From: Clerk [REDACTED]
Sent: 24 June 2021 10:08
To: Planning.Responses <Planning.Responses@arun.gov.uk>
Subject: RE: Planning Consultation on: BN/62/21/PL

Application No: BN/62/21/PL
Registered: 20th May 2021
Site Address: The Croft Surgery Barnham Road Eastergate PO20 3RP
Grid Reference: 494676 105538
Description of Works: Medical centre with pharmacy retail unit & other ancillary uses together with access onto Barnham Road, associated car parking and other hard and soft landscaping works. This site is in CIL zone 2 (Zero Rated) as other development.

PROPOSED SITE PLAN

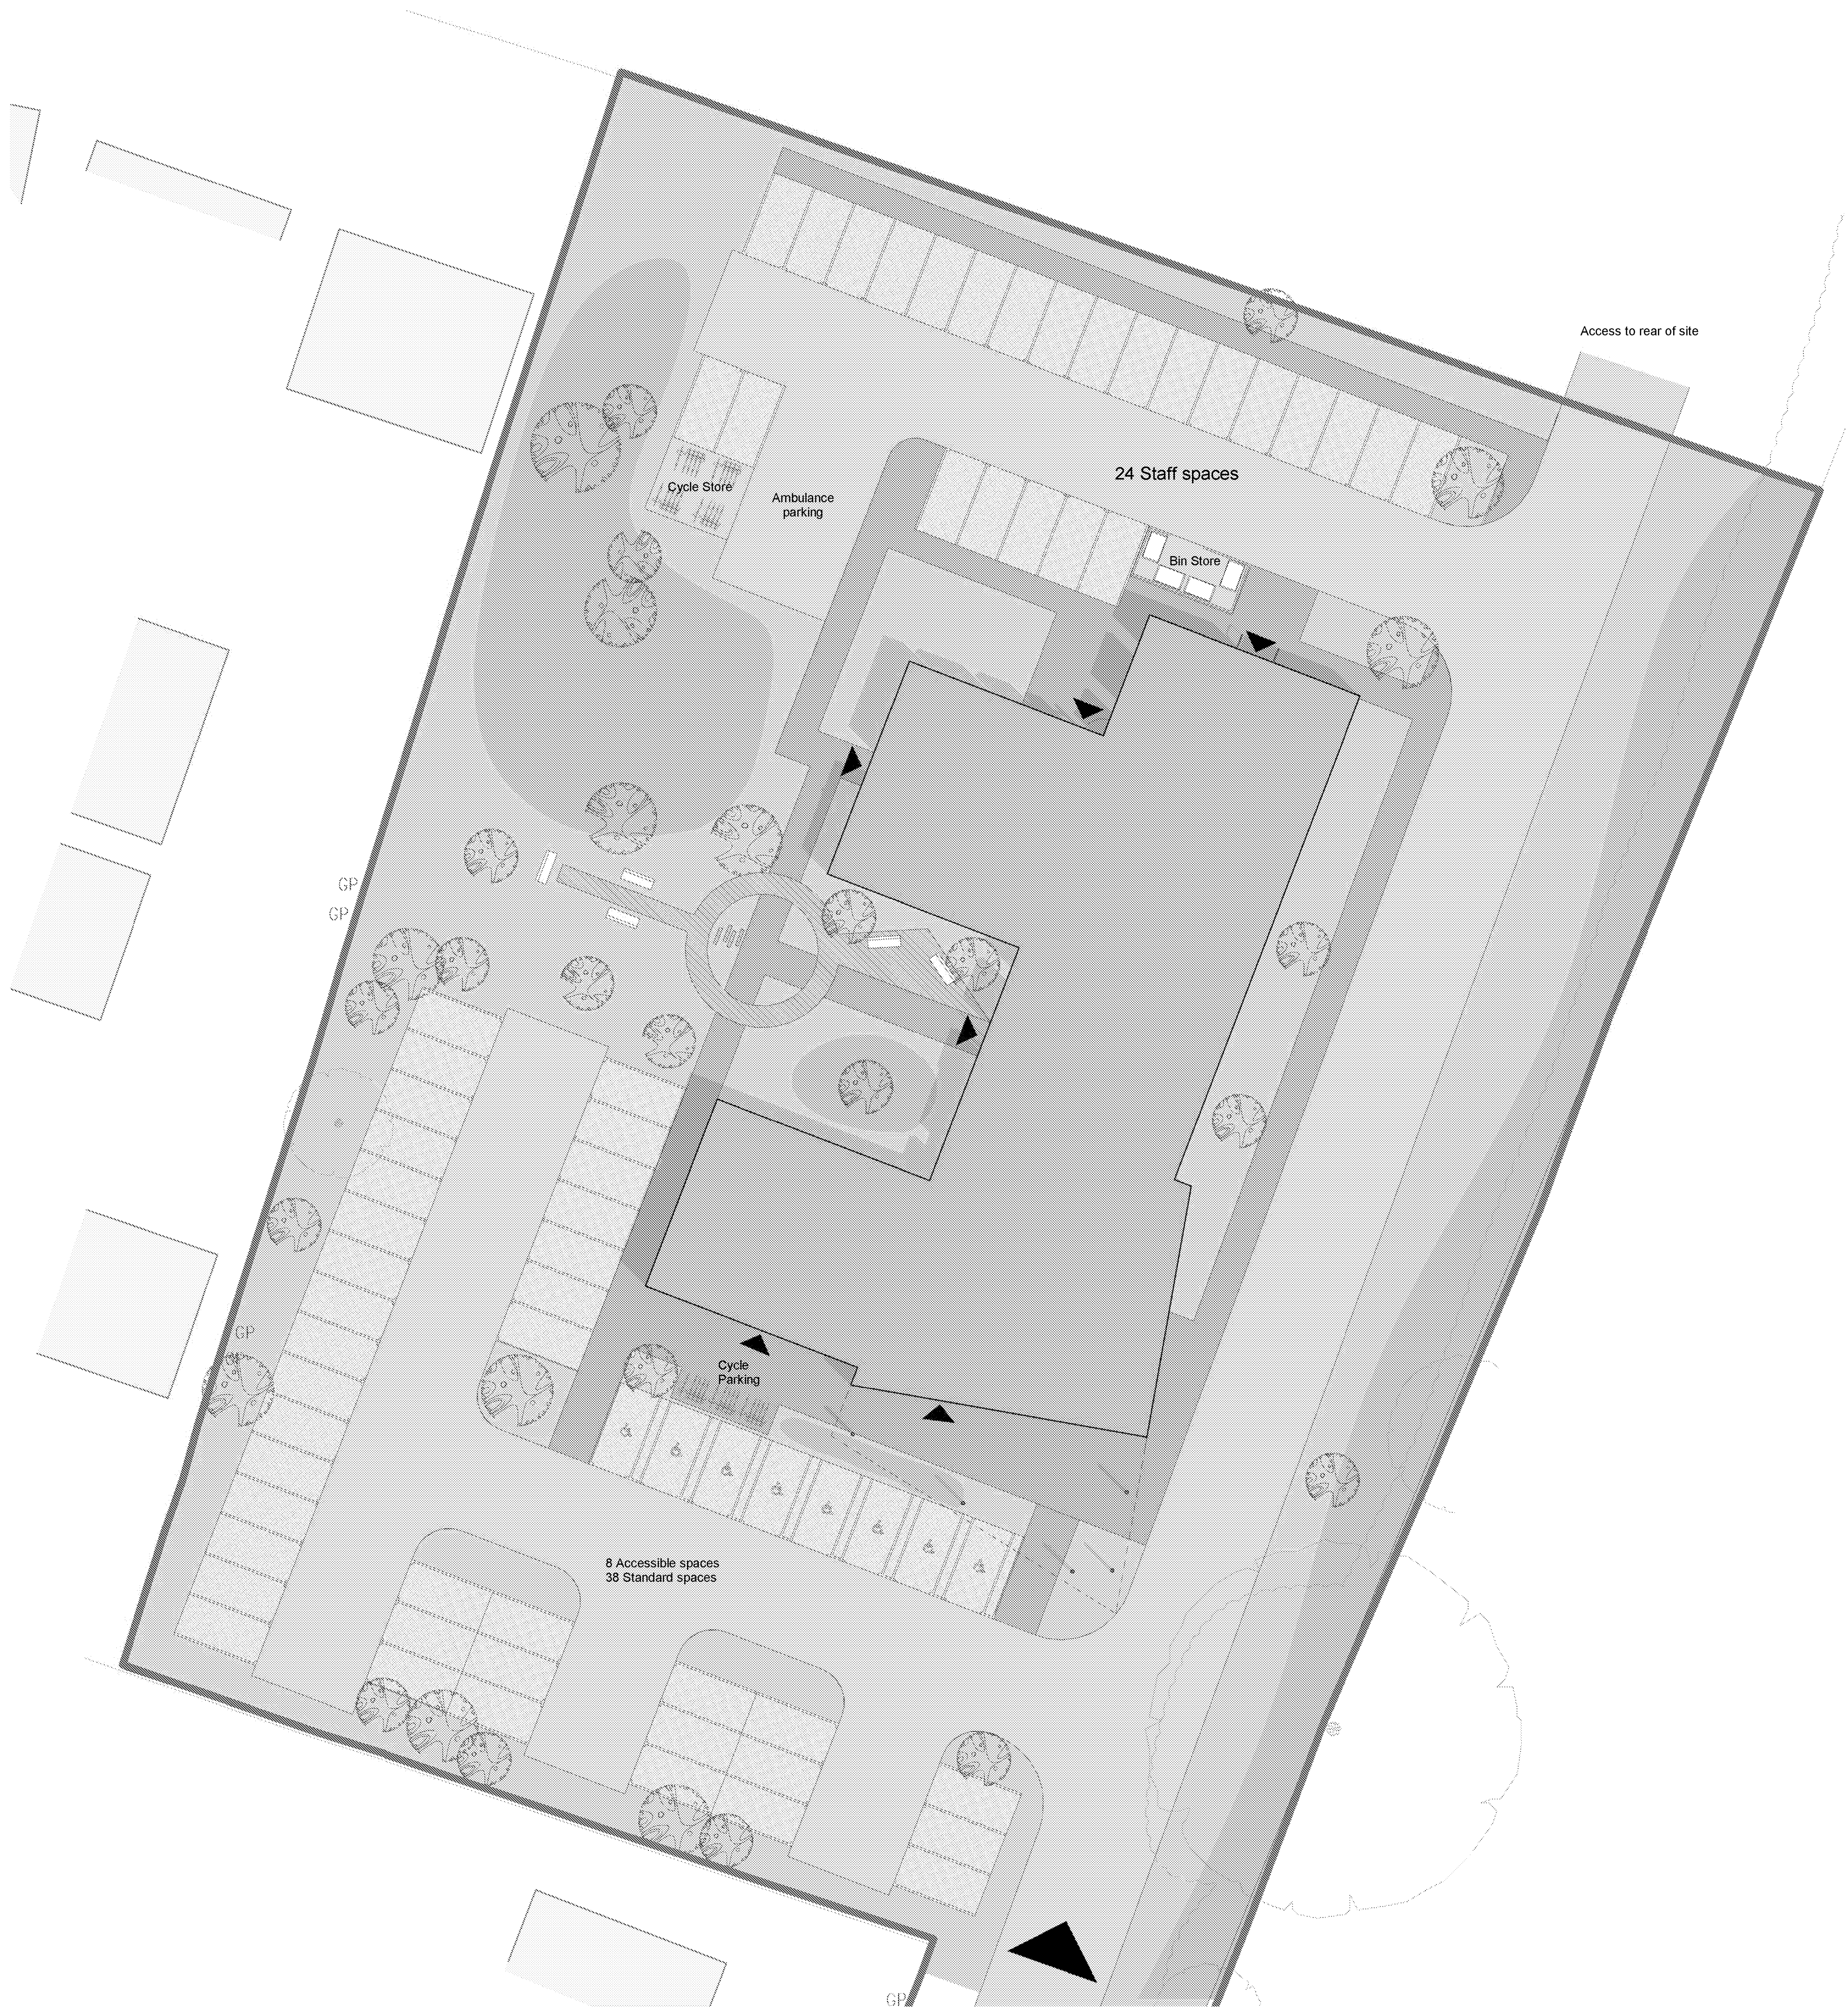
- Lack of site permeability and specifically lack of connectivity to the proposed Barratt housing behind the site (Arun District Council Strategic Development 5) and beyond to the Dandara development at Fontwell. Also no engagement with the plans for the proposed fit trail and a lack of connectivity with this proposed site. Overall, a concern that the development will not be integrated into the surrounding village landscape in a sustainable manner.

- Future plans for the current surgery – the Committee were concerned for its future use.
- The highway access gave major concerns as currently queues are occurring with a much lower number of people accessing the current surgery. Whilst a new access road would be built there were still issues around capacity with the additional housing proposed for the area, which until the A29 realignment scheme is completed will mean significant additional traffic movements along Barnham Road. The PC wish to see the latest new housing numbers used in connection with this proposal and would welcome the discussion of enhancements to Barnham Road with traffic mitigation measures at the site entrance.
